Online Comment

Application H09-1168-25
Location Jewson Ltd Boston Road South Holbeach PE12 7LR
Proposal Proposed Signage

Name Greg Watkinson
Address Conservation Officer

PROPOSED FRONT ELEVATION
SCALE: 1/100 @A3

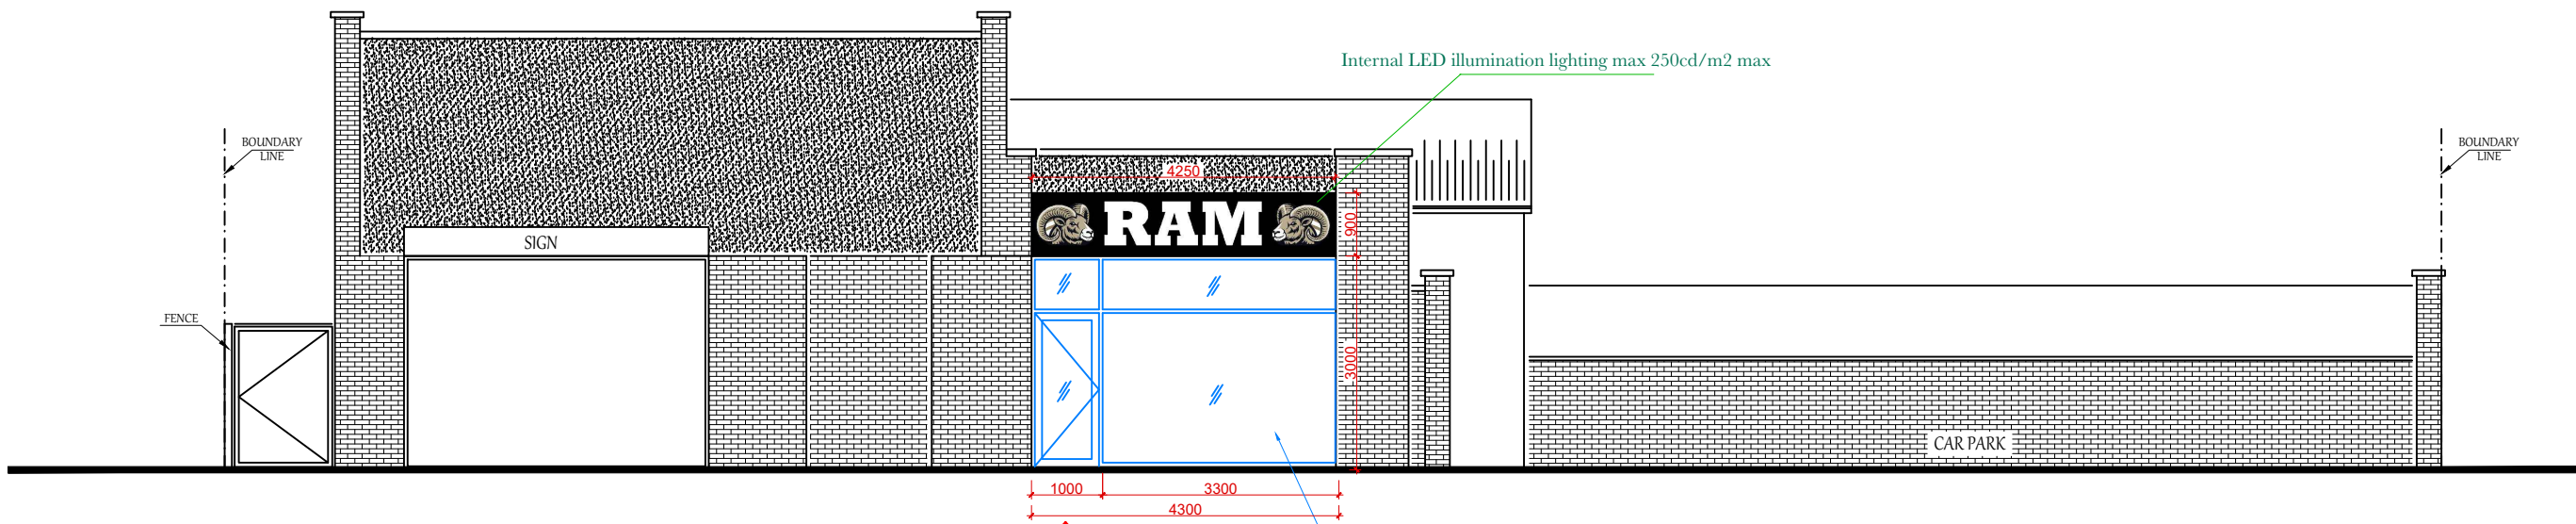
The proposal here is for internally illuminated signage.

Such signage is typically unacceptable in Conservation Areas. Whilst the site is just outside of the conservation area, Policy 29 of the SELLP does offer protection to sites that exist within views into and out of the conservation area, which this site plainly does.

However, with that said, this site specifically is not within the setting of any listed buildings and is within a commercial setting characterised largely by late C20th commercial and industrial sites, with very little traditional commercial character. Moreover, the site is situated across the road from Tesco, which already features extensive internally illuminated signage.

Therefore, whilst the site is within the setting of the conservation area, in the balance of probabilities, I do not find that the acceptance of this proposal would present any additional risk to the character of the Conservation Area.
